To: Lisa Rasch
Subject: RE: 23/2762/DOC - Discharge of conditions 5 & 6 on application 23/2762/doc

Subject: 23/2762/DOC - Discharge of conditions 5 & 6 on application 23/2133/FUL

Condition 5 – Landscaping

Condition 6 – Biodiversity Net Gain

## LANDSCAPING AND BNG PLAN - PA-04

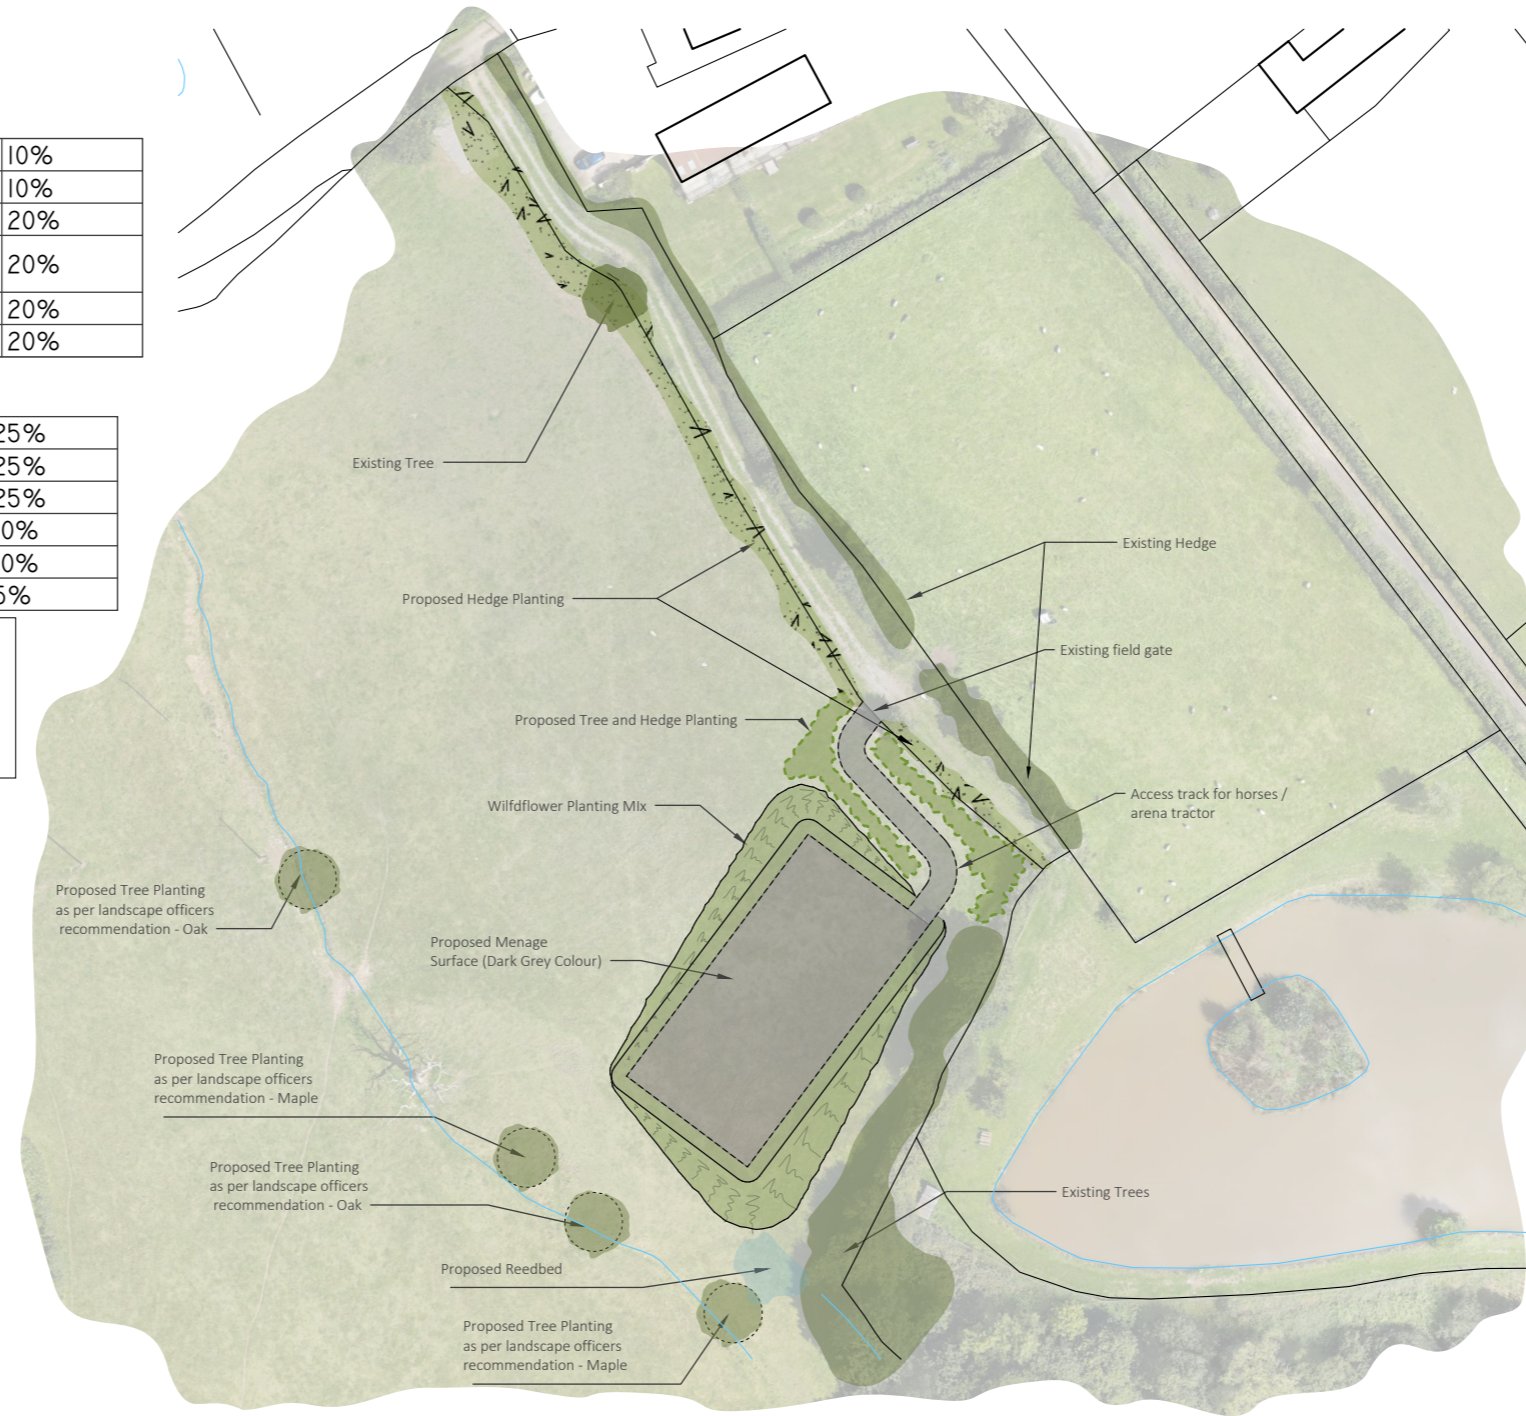
i) Planting plan(s) showing locations, species and number of new tree and hedge planting, type and extent of areas to be grassed and of existing vegetation to be retained and removed. The planting ratio is indicated for areas of new hedge planting (6-8 plants per metre) but it is unclear on the number of new hedge plants/trees for areas marked as 'Proposed Tree and Hedge Planting'. Furthermore, planting '...along the edges of top of the bank...' are referred to but the plan refers to hedge planting and not hedgebank creation? The plan is also unclear on the planting size and species of the 4 no. new specimen trees indicated, this should be clarified on the plan.

ii) Plant schedule indicating the species, form, size, numbers and density of proposed planting. See above.

iv) Tree pit and tree staking/ guying details – No details provided.

We will, in due course, consult our ecologist on the details provided but at this stage it is unclear how the BNG specified in the submitted data sheets is to be delivered, for example creation of reedbeds are indicated but no details of this are provided on the landscaping plan and 'Species-rich' native hedgerow with trees is indicated but the landscaping layout plan indicates the proposed hedge planting to comprise of just 2 no. species and would not therefore comprise of 'species rich' native hedgerow. The information provided looks to indicate what is required to provide BNG but lacks information on how it would be delivered.

Please find attached an amended plan in line with your comments, and updated BNG calculations.

The hedgerow planting schedule will be as follows:

On the 94m of new hedgerow:

- Hazel - 165 plants
- Holly mix - 165 plants
- Wild Cherry - 165 plants
- Pedunculate Oak - 65 plants
- Crab Apple - 65 plants
- Wild roses - 32 plants

On the 21m of new hedgerow:

- Hazel - 37 plants
- Holly mix - 37 plants
- Wild Cherry - 37 plants
- Pedunculate Oak - 14 plant
- Crab Apple - 14 plants
- Wild roses - 7 plants

As per the landscape and BNG plan, the plants will be planted in two staggered rows of 6-8 plants per metre.

Proposed tree planting schedule:

Trees to be scattered within the hedgerow planting, leaving adequate room for roots spread/growth.

As per the amended landscape and BNG plan the trees will have pits of 30-50cm (2-3 times the width of the root ball/spread) and will be covered with wire mesh to protect from deer. Mesh will be monitored and removed when the tree is of a suitable size.
